Our ref: MP 10_0158

Major Project 10_0158 – Residential Development Buildings 7 & 8, 61 Mobbs Lane, Epping

ADDITIONAL INFORMATION REQUIRED

1 STREET ELEVATION
1:200

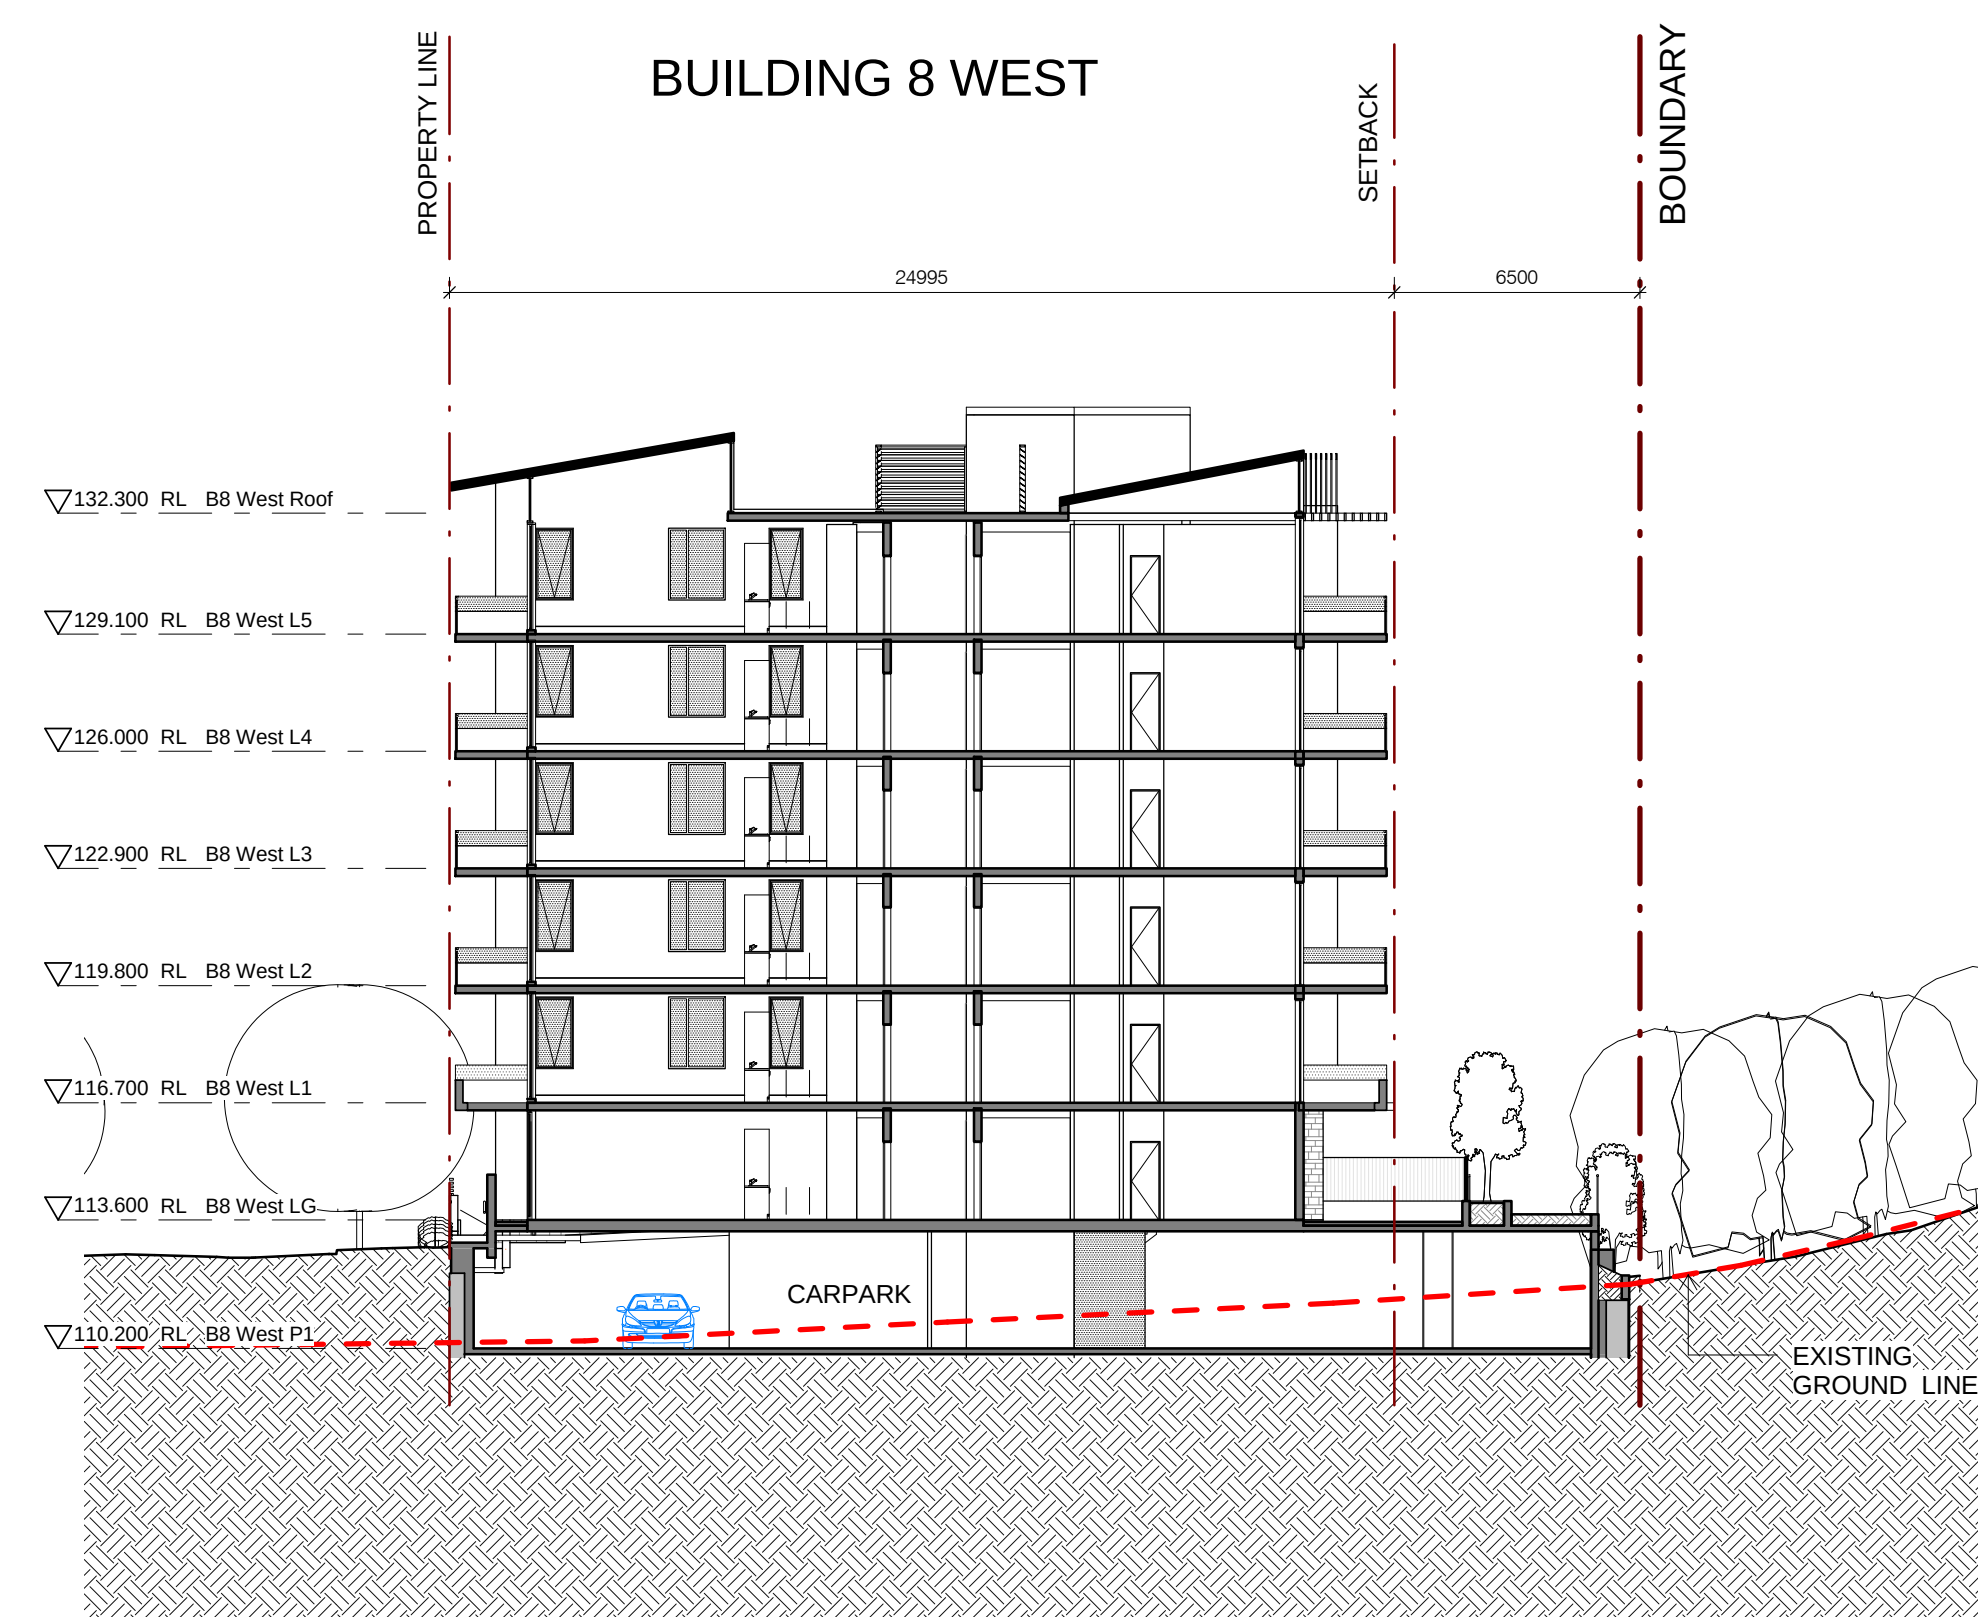
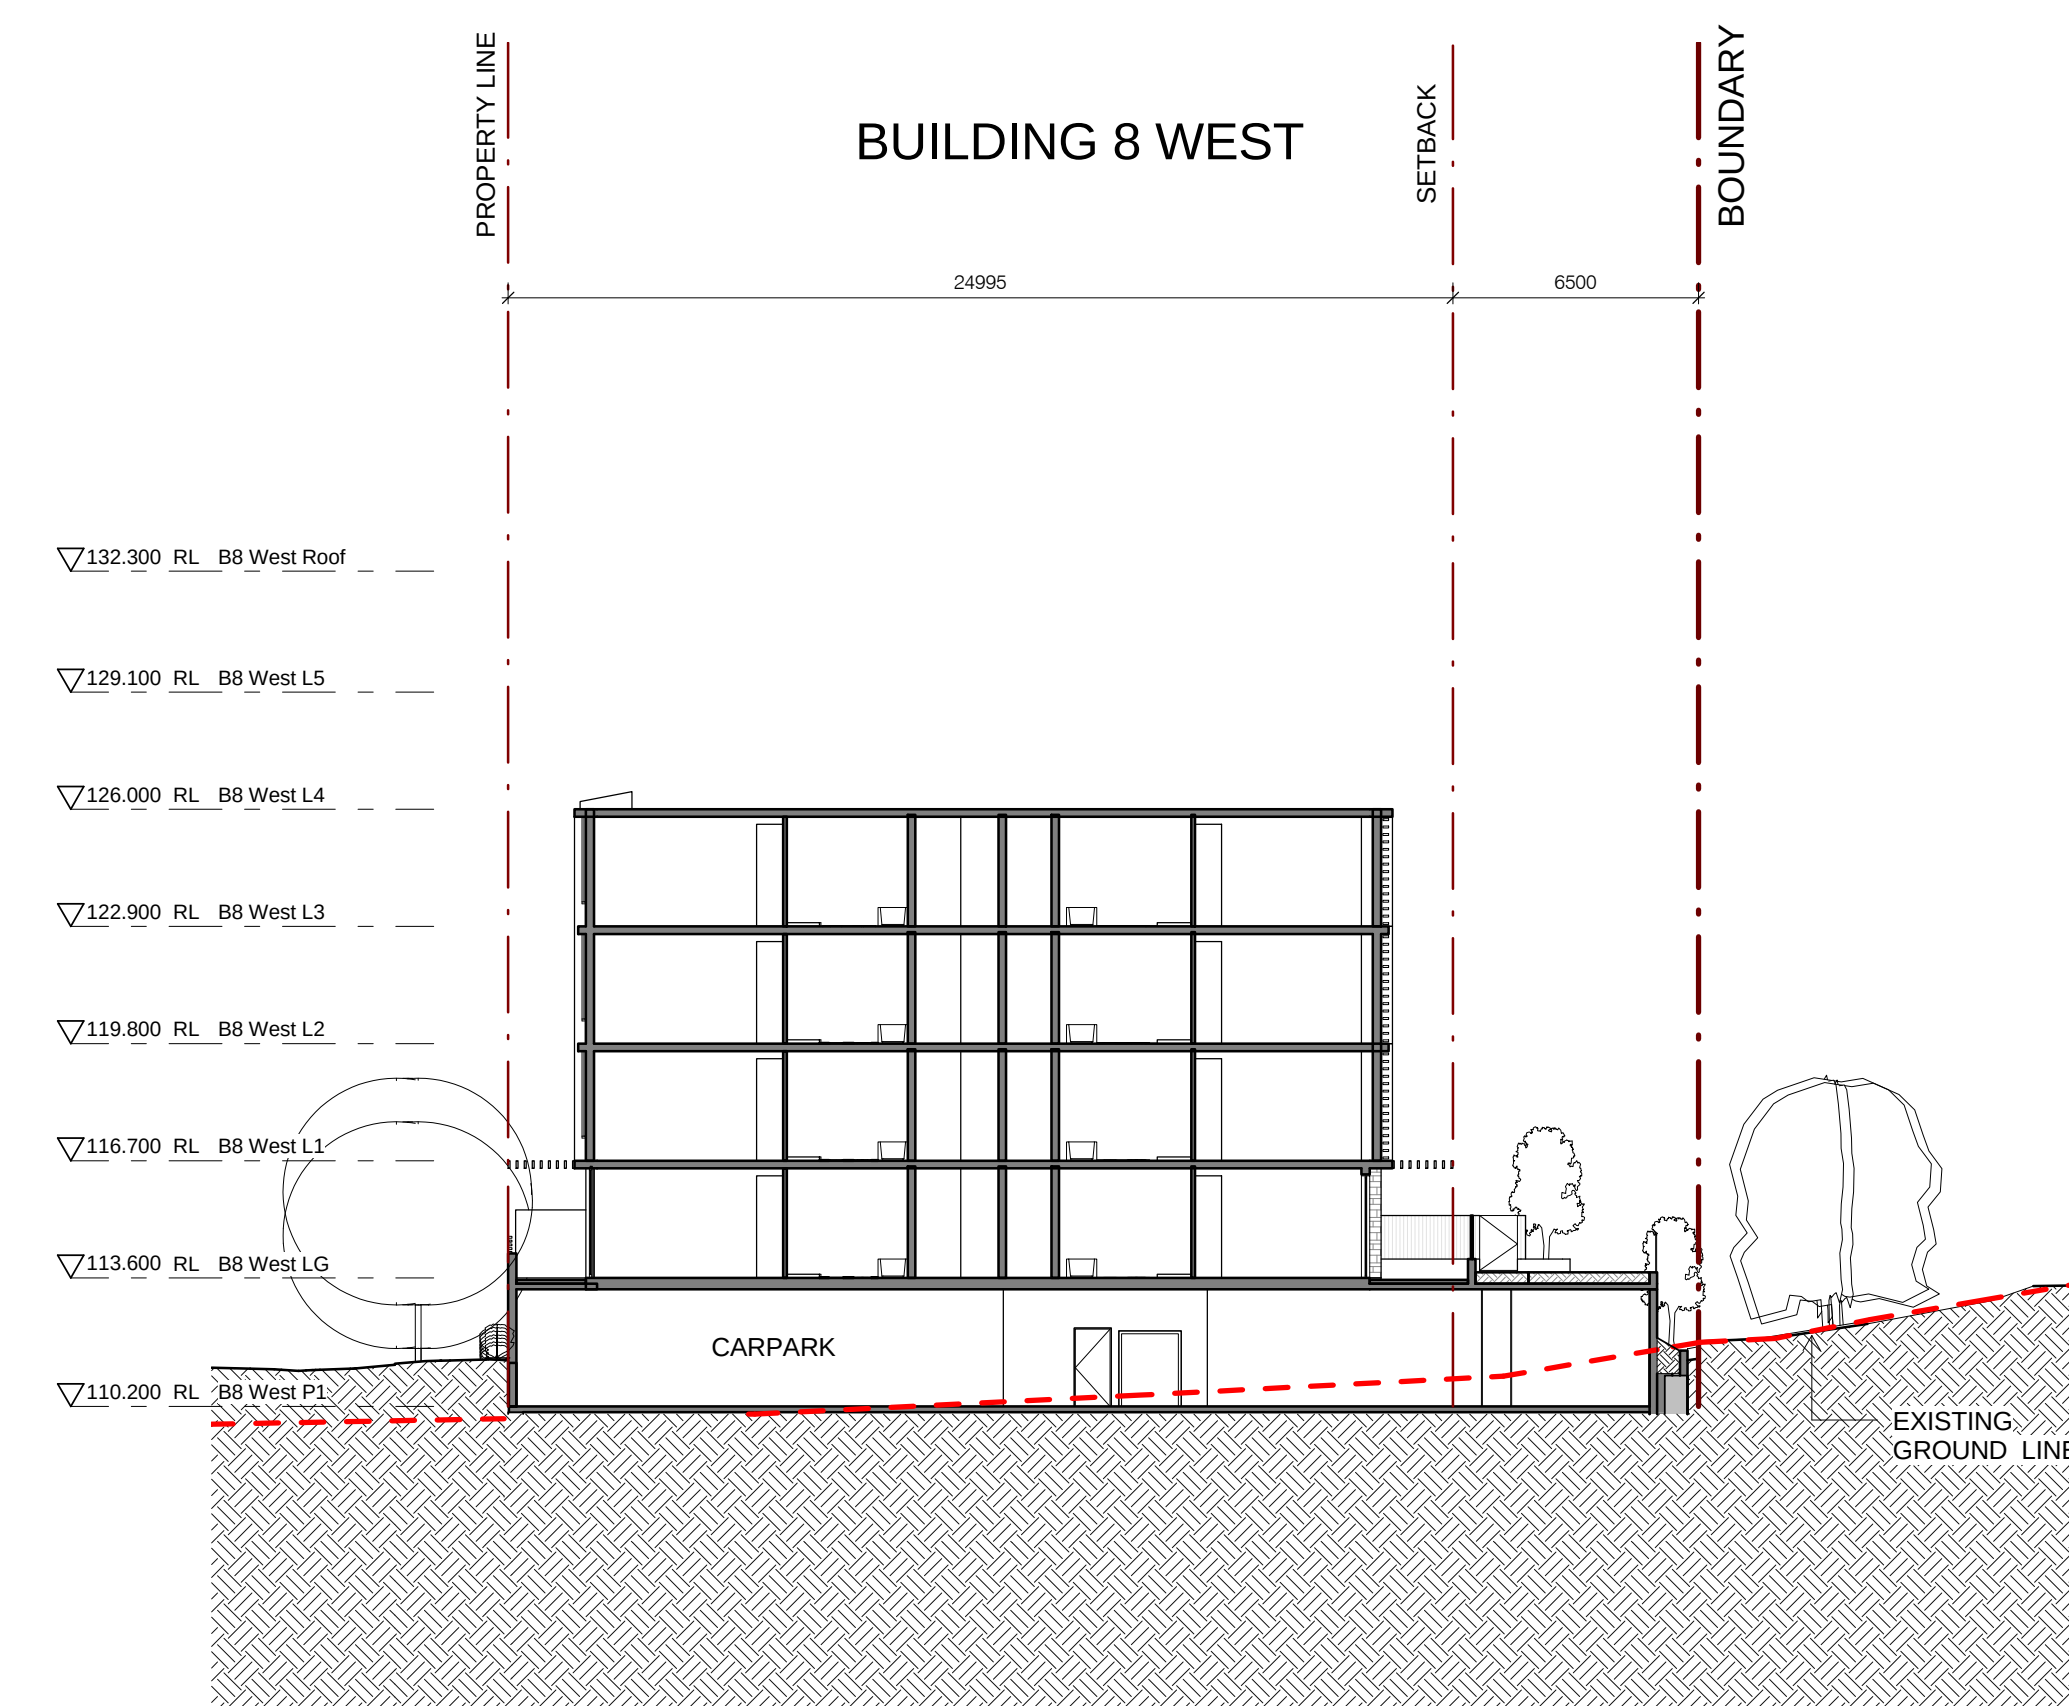
Concern is raised regarding the height of the western part of Building 8. This part of the building appears to exceed the 6 storey height limit prescribed under Schedule 3 of SEPP (Major Development). The height of the building should be reduced to comply with the SEPP's height controls. Furthermore, basement projections should not exceed 1.2m above natural ground level.

All revised drawings are to be submitted at an appropriate/accurate scale on A1 sheets. All elevation plans shall indicate existing natural ground levels and proposed natural ground levels.
